## Garage Barn, Studio Cottage, Tarlton

Proposed Replacement of the Garage Barn at Studio Cottage, Tarlton

Non-Material Amendment - Covering Statement

June 2021

Drawn	Checked	Approved	Rev
CT	JA		B
Title			
Proposed Site Location Plan			
Drawing Number			
0844_2001

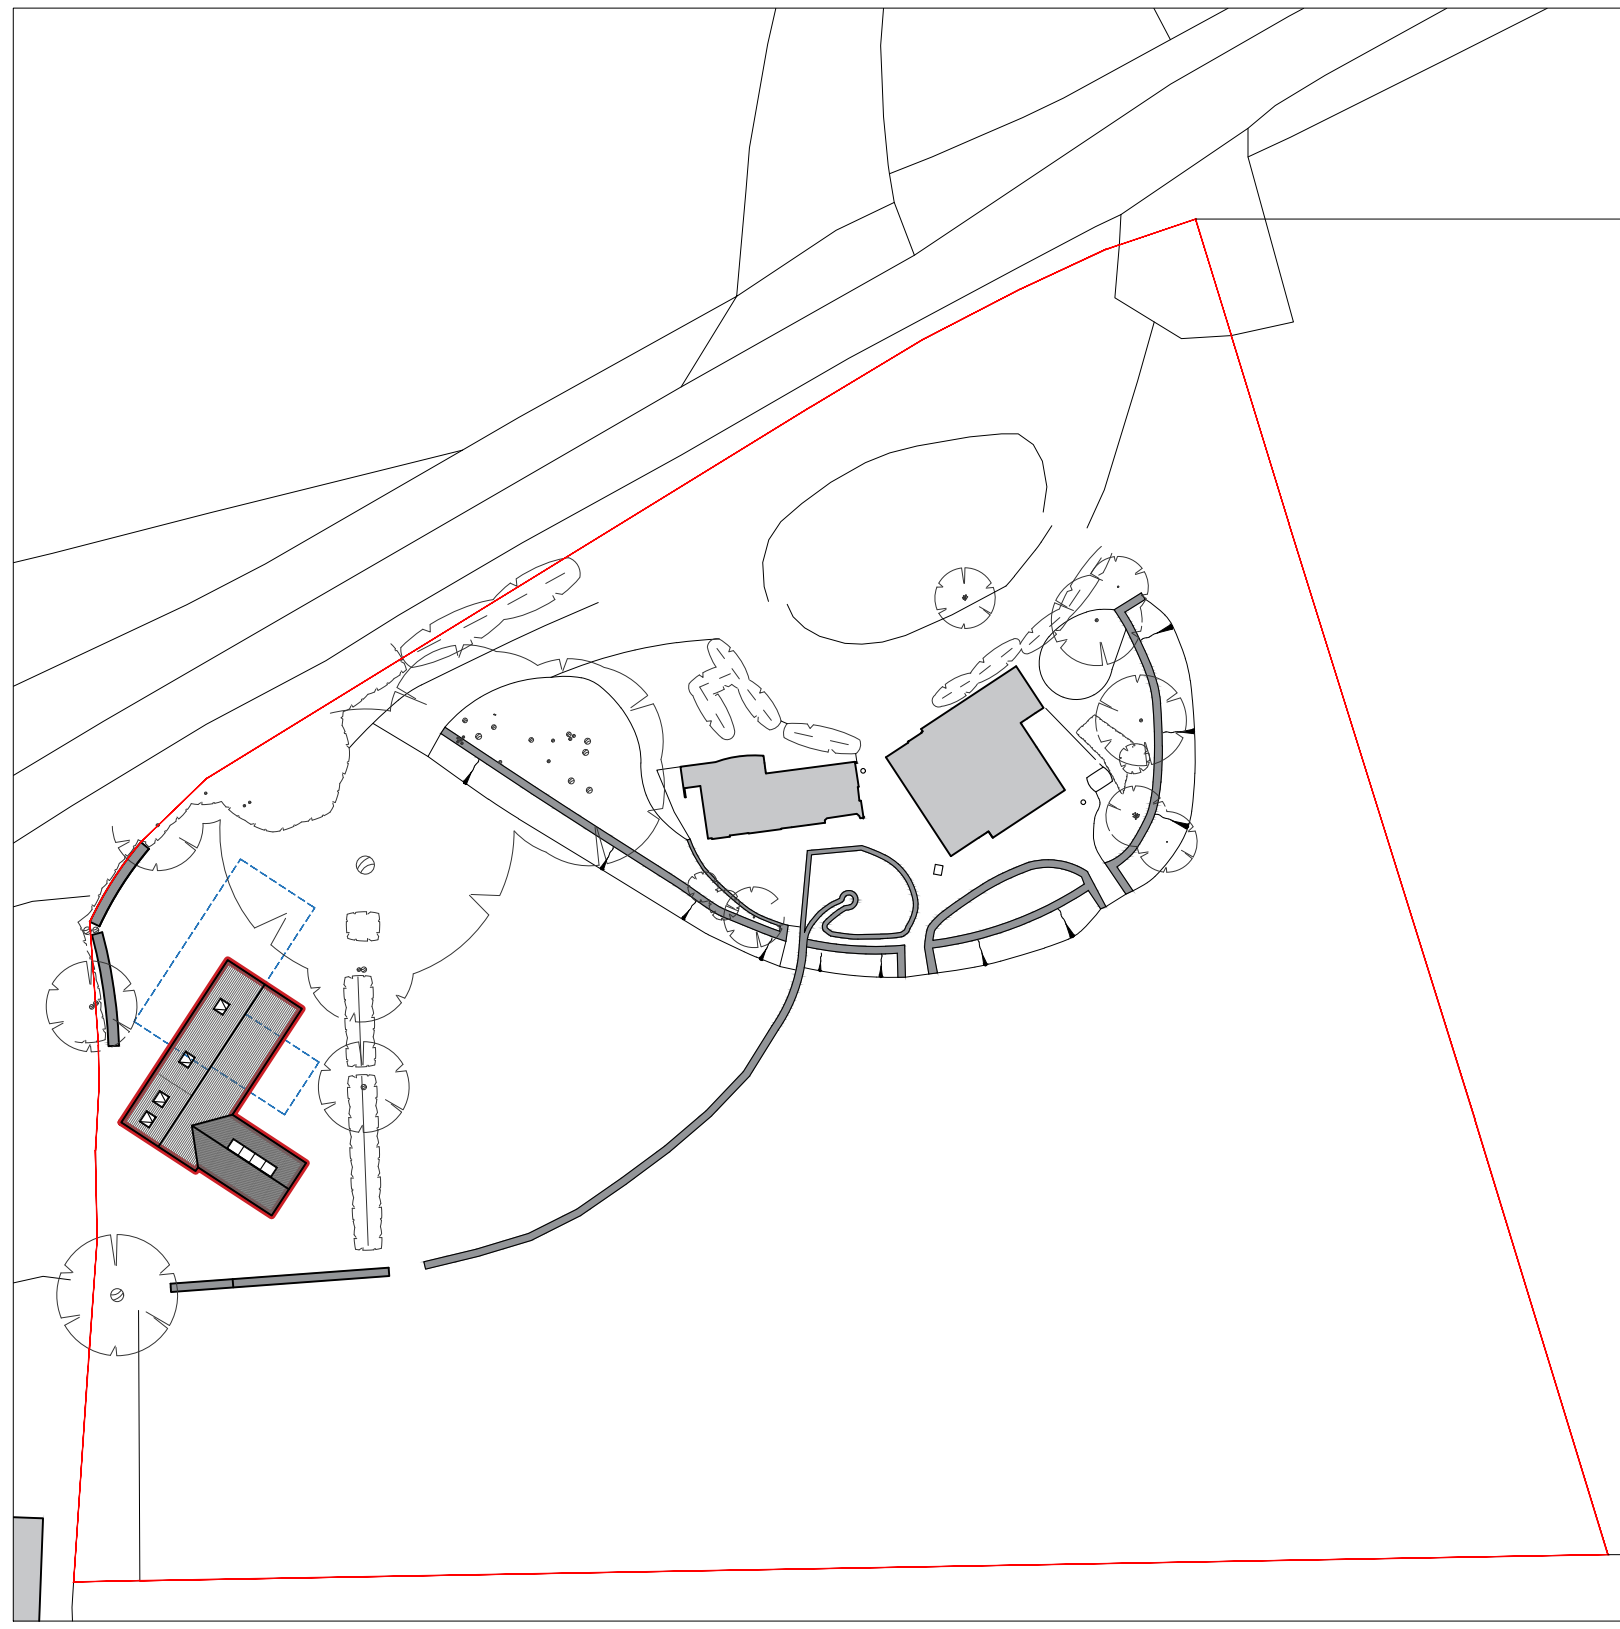
As a result of arboricultural advice received, including the tree survey shown to the right, and outline structural design of the foundation provided by Webb Yates (Structural Engineers) it has been determined that it is necessary to move the location of the proposed barn slightly to the south in order to avoid damaging the root systems of the large walnut tree (indicated T8 on the tree survey on this page).

Drawn	Checked	Approved	Rev
CT	JA		B
Title			
Proposed Ground Floor Plan			
Drawing Number			
0844_2105

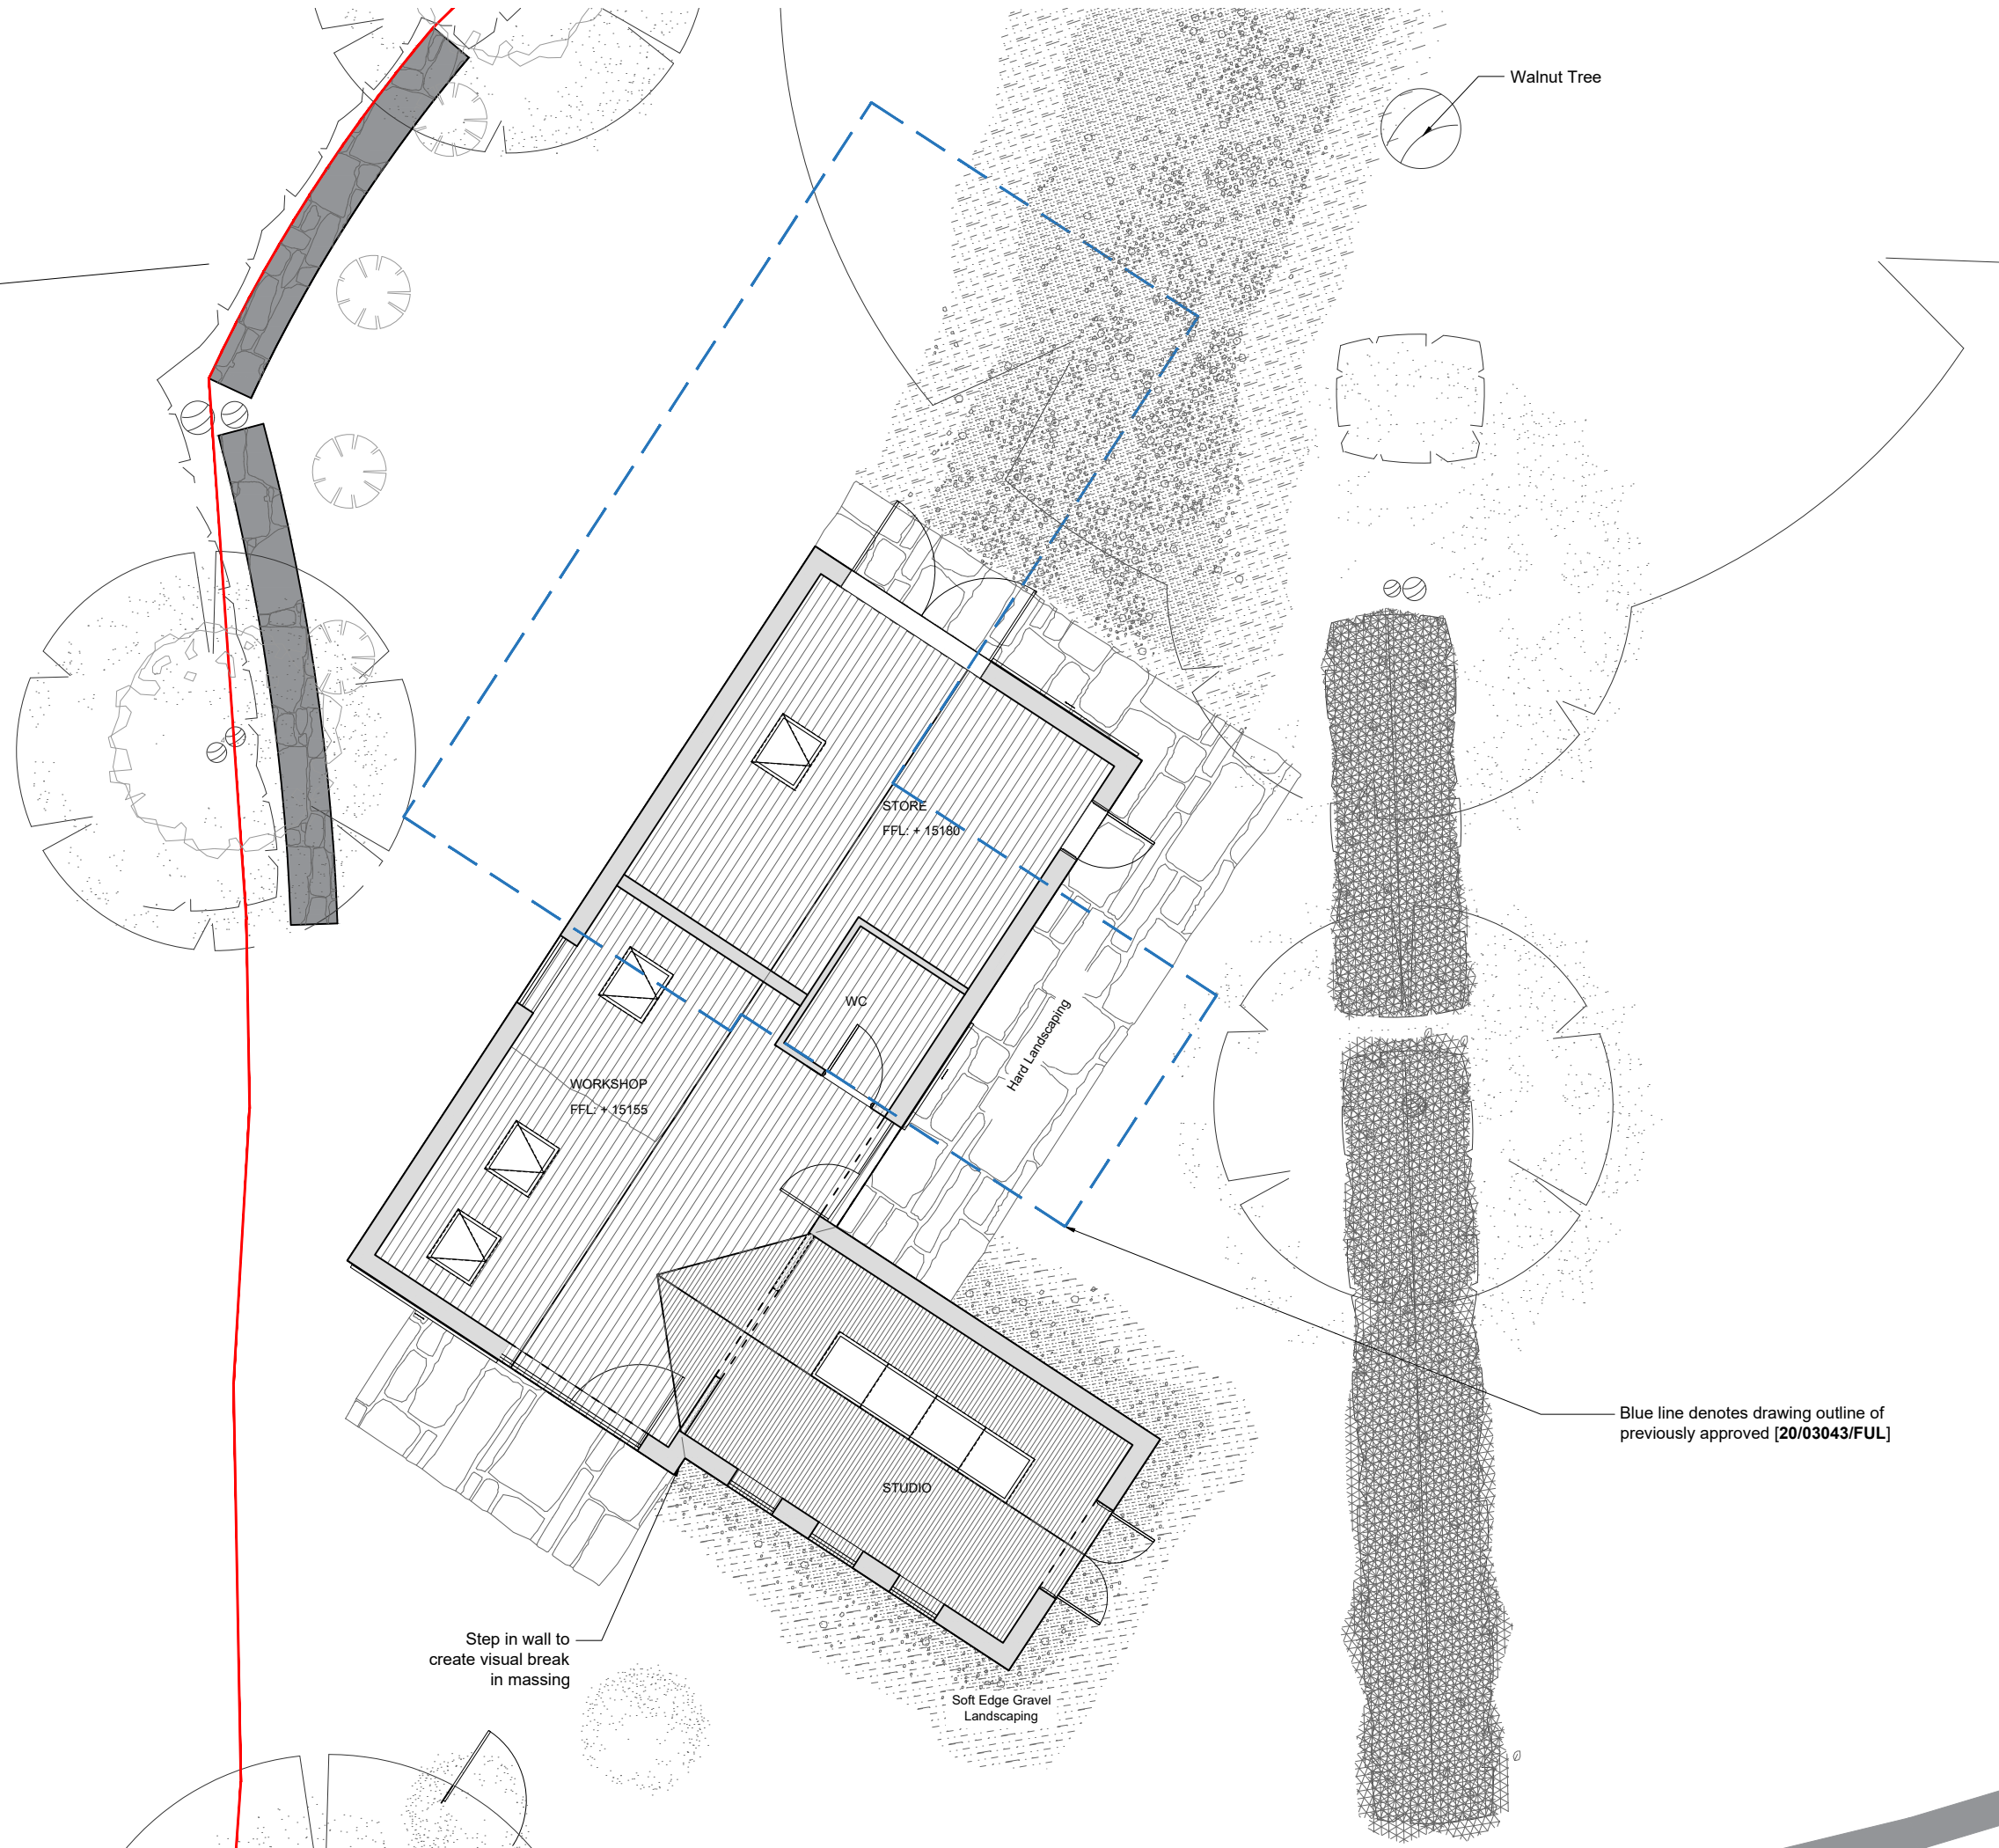
In order to suit the site levels of the new location, the floor levels will be adjusted slightly as indicated on the proposed plans, though the ridge height will remain unchanged.
